CITY OF ALBUQUERQUE

Re: Francisco Lopez, Bridge/Eucariz Grading & Drainage Plan (L-11/D067)
Lot 316A, Unit 3, Town of Atrisco Grant Engineer's Stamp dated 07-20-12

Based upon the information provided in your submittal dated 07-25-12, the above referenced plan cannot be approved for Preliminary Plat Approval or Building Permit until the following comments have been addressed:

## GRADING & DRAINAGE PLAN

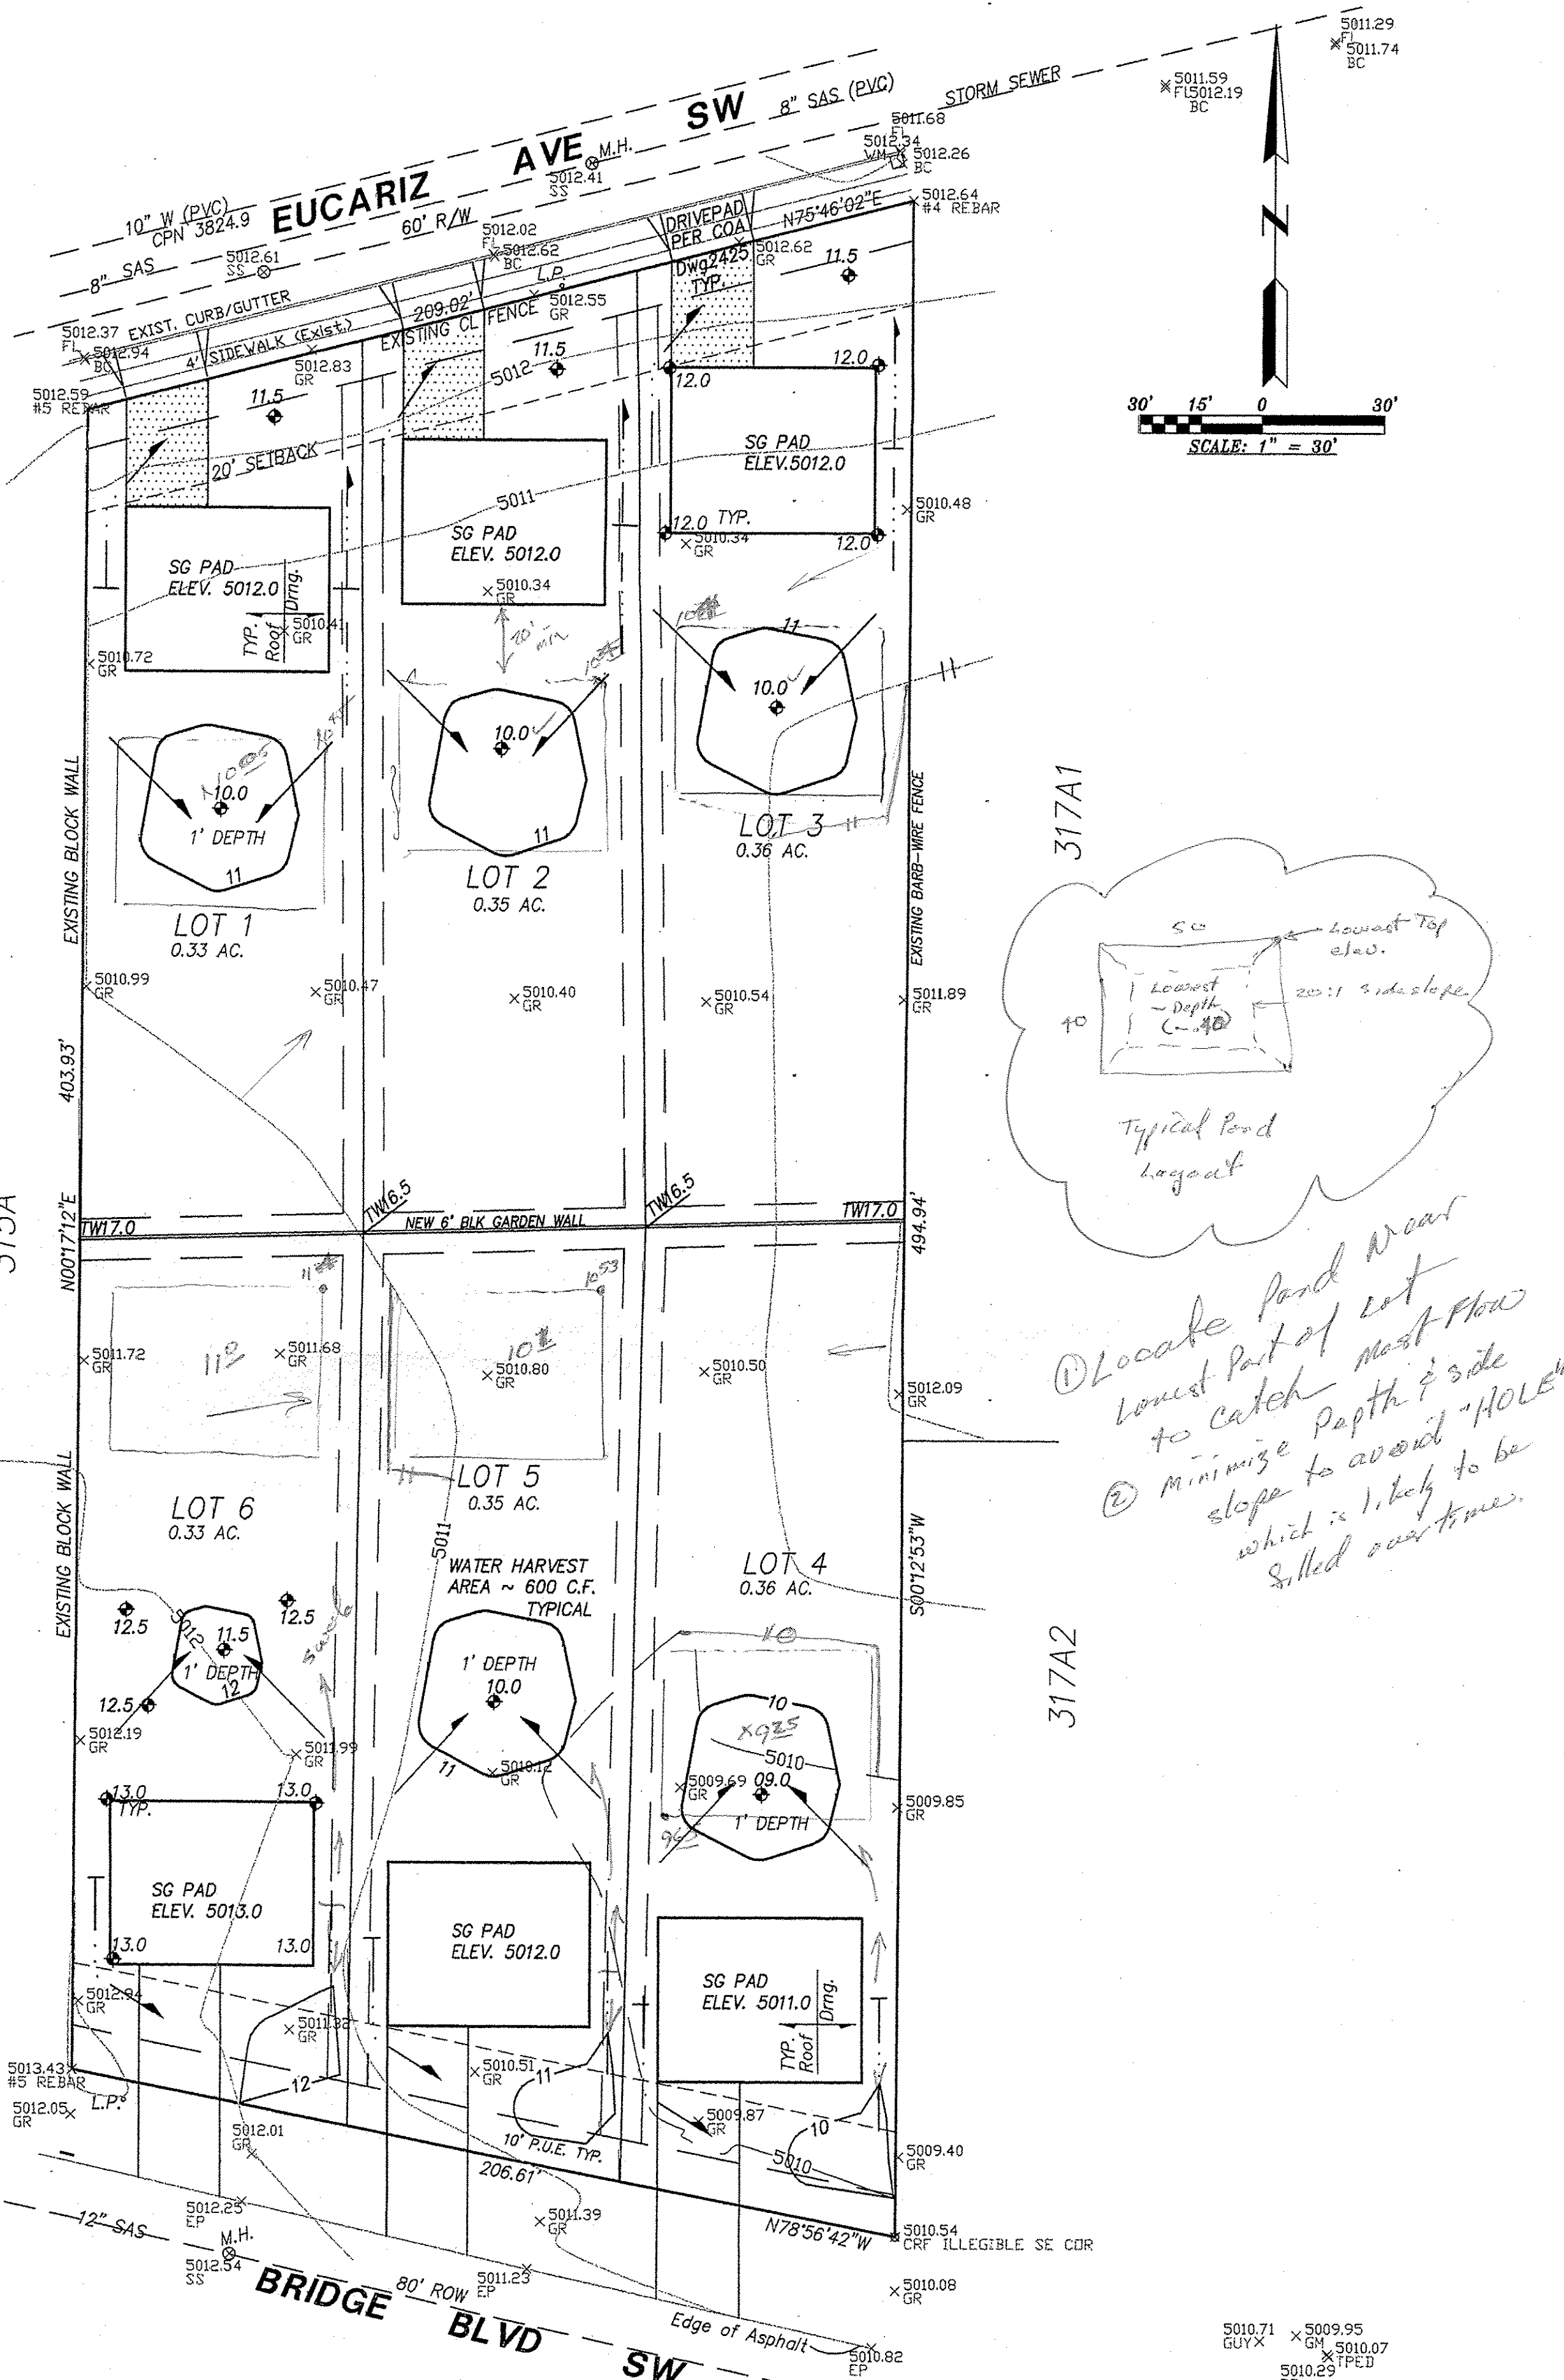
- Please show the depressed backyard ponding areas on the grading plan.
- Provide pond calculations for each of the backyard ponds.
- Include all proposed contours on the plan.

- Various proposed swales do not have arrows indicating the direction of the flow. Will the proposed southeastern swale affect the existing structure on adjacent Lot 317A2?

- It appears the swales along the northern property line also direct flow east to Lot 317A1.
- Lots 2 and 5 are not labeled on the plan.
- Provide additional spot elevations around the four corners of the house pads on all lots as you have done for Lot 6.

- Lots 1 and 4 show the roofs pitching to the east and west, is this typical for the remaining homes?
- Top-of-wall elevations are needed for the proposed block wall separating the northern and southern lots. Please include a detail of this wall in the grading plan.

- The existing contours shown on the plan should be carried out another 20 feet from the property lines.
- Grades and pad elevations on the Bridge side should anticipate future C&G and sidewalk improvements, which will result in higher grades along the southern property line.
